DELEGATED HOUSEHOLDER DECISION

Erection of a first floor side extension

67405/APP/2011/1278 16 THORNTON AVENUE WEST DRAYTON

PROPOSED GROUND FLOOR

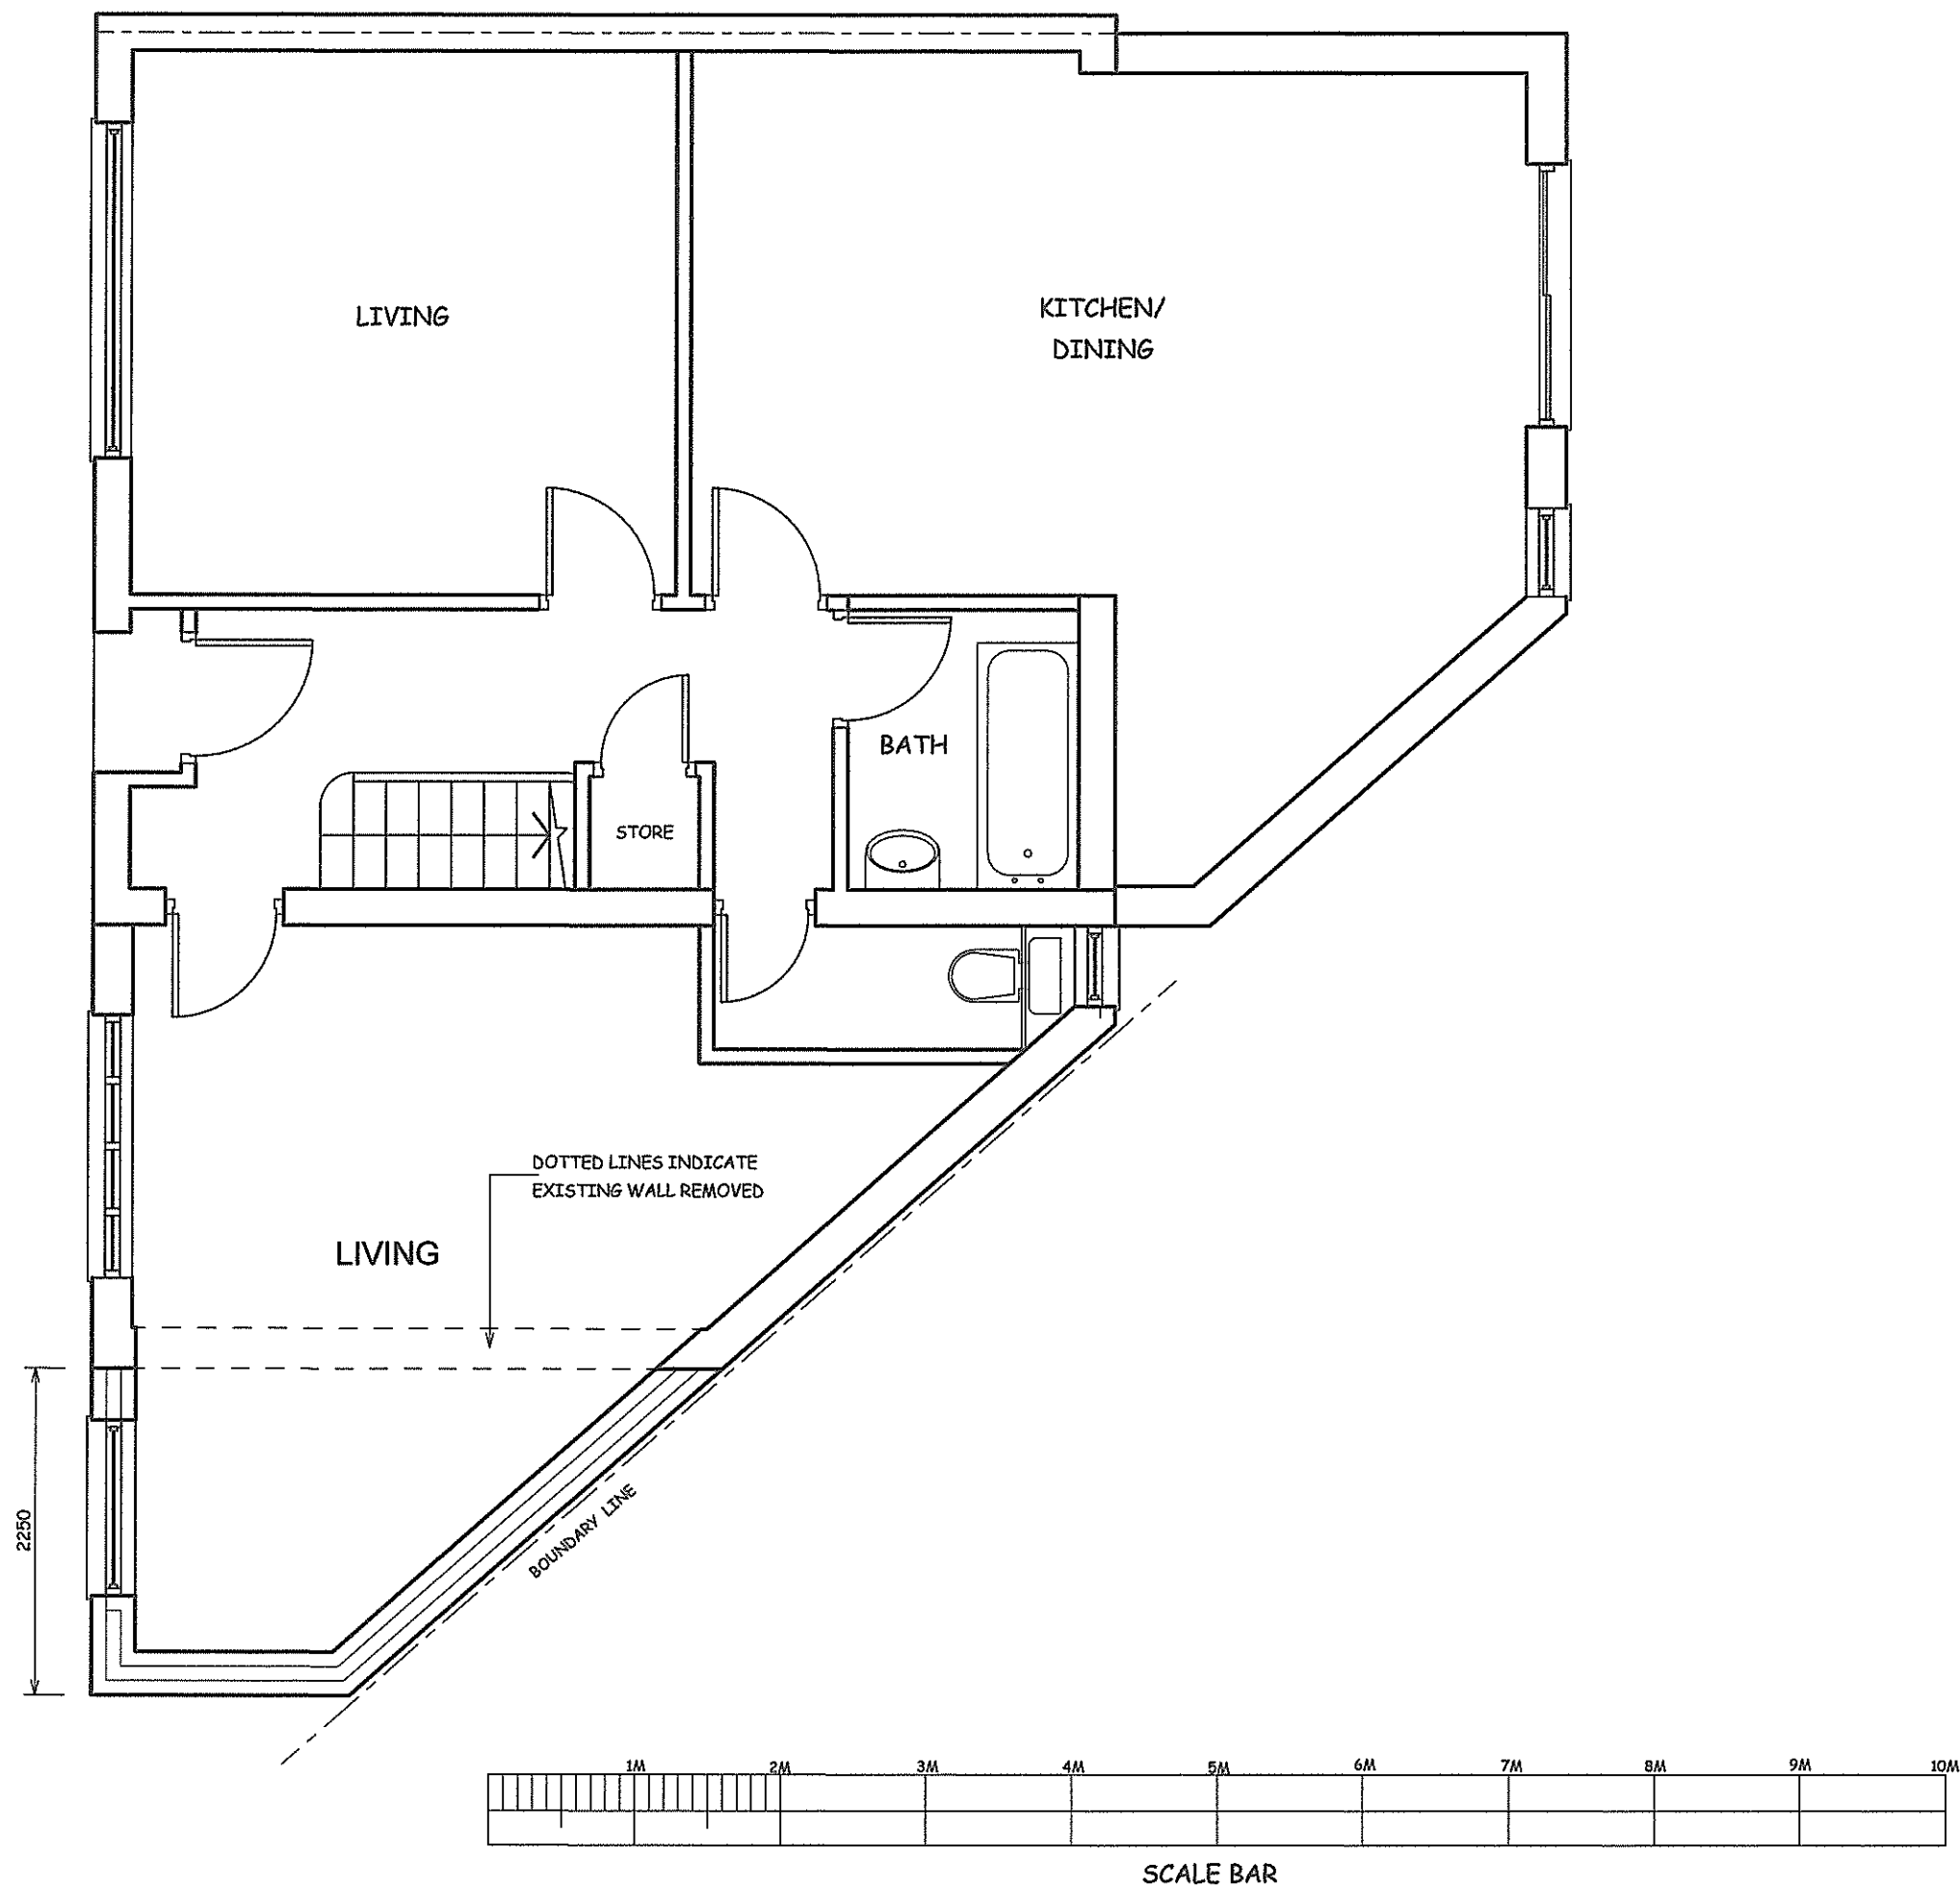
The application site benefits from a single storey flat roof side extension which is set flush with the front building line. The application proposes to extend the existing single storey side extension by a depth of 2.2m and a maximum length of 4.2m extending up to the boundary with No. 14. The proposal then seeks to construct a first floor side extension over the existing and proposed ground floor side extension. The two-storey element will measure a depth of 5.3m, a length of 6.45 and a a hipped roof measuring a maximum height of 7.7m.

PROPOSED FIRST FLOOR

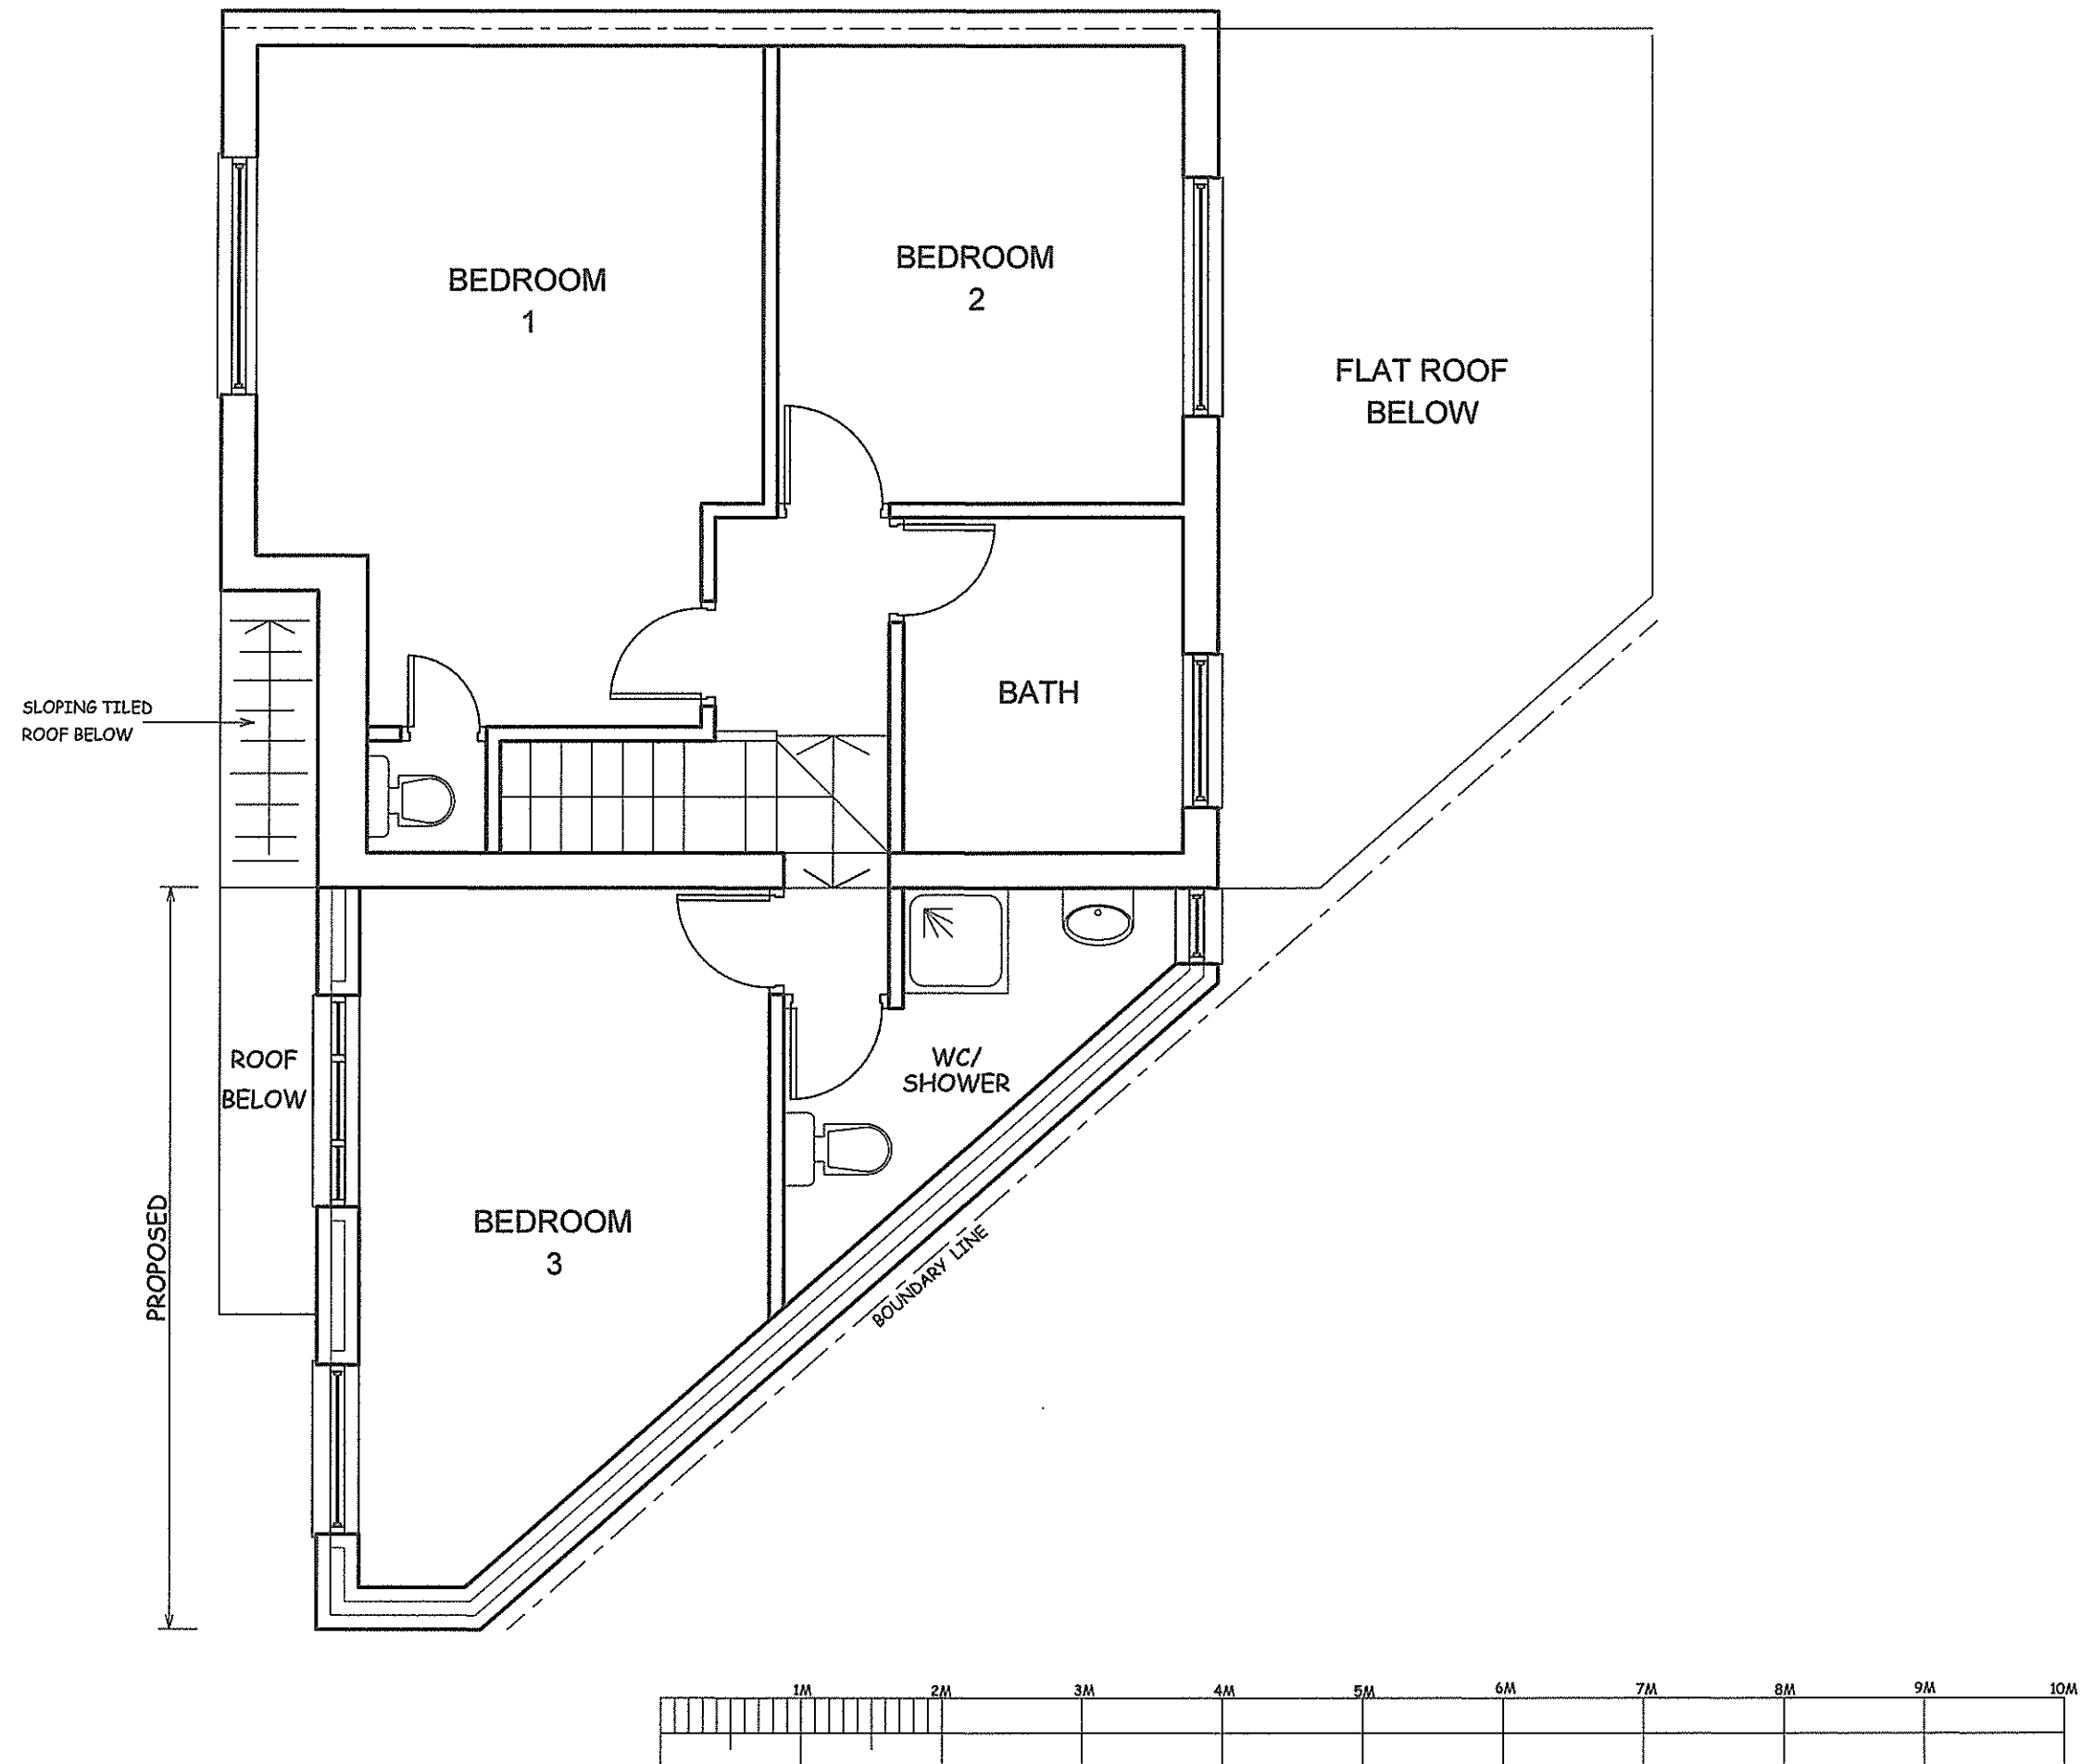
The proposed two-storey side extension is located flush with the existing front building line, is not set down from the ridge of the host dwelling and is built up the shared boundary with No. 14. The proposal measures a total width of 5.3m and exceeds more than half the width of the original property (6.1m). In policy terms, the proposal does not comply with Policy DMHD 1. It would fail to represent a subservient nor subordinate addition to the host dwelling. The proposal appears as an overdevelopment of the site and results in an overly large award and cramped appearance.

No. 14 is located to the east of the site and comprises a two storey semi-detached dwelling. The proposed two-storey side extension would be located hard up against the shared boundary with the neighbouring property. Due to the orientation of the two properties, the proposed first floor side would be located only 0.9m from the entire two-storey side flank wall of No. 14, with the only separation being accommodated by a shared access. It is noted that there is a first floor window on the No. 14 facing the application site, whilst it is acknowledged that this appears to serve a bathroom, the proposed first floor side would be located within extremely close proximity that would result in the window facing a two-storey flank wall. Given the proximity of the development to the neighbouring property, the proposal would be detrimental to the amenities of No. 14 by virtue of visual intrusion, enclosure, overbearing impact and overdominance.

PROPOSED ELEVATIONS

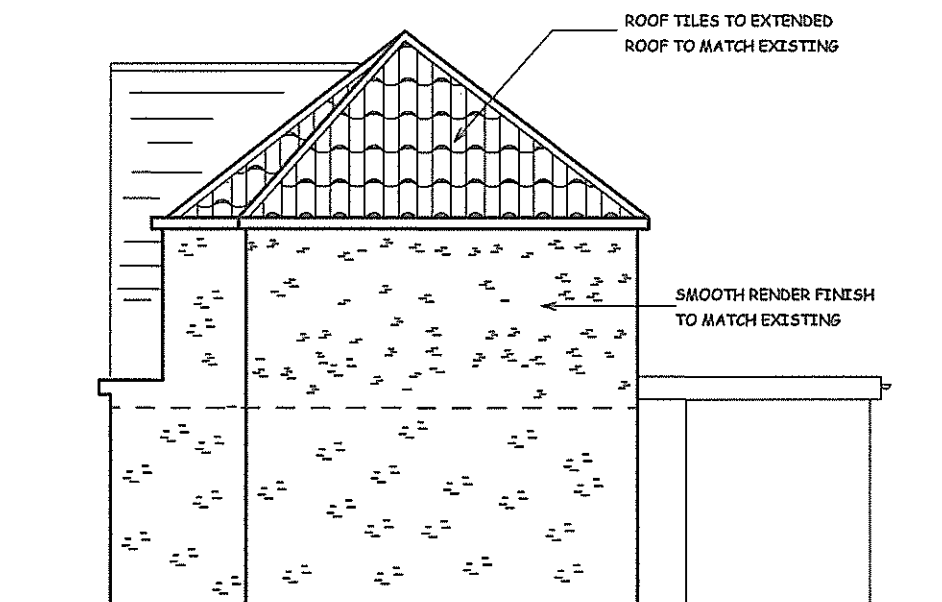
In terms of the street scene, the application site is already located within close proximity to the No. 14 Thornton Road located to the west of the site. The proposed two storey side would be located harmfully close to the neighbouring site, and the neighbouring property. Notwithstanding the impact upon residential amenity, it would have a harmful impact on the character and appearance of both the application site and the neighbouring property, essentially boxing the neighbouring in from their eastern elevation with an awkwardly angled extension. This would reduce the building separation from most vantage points in the street.
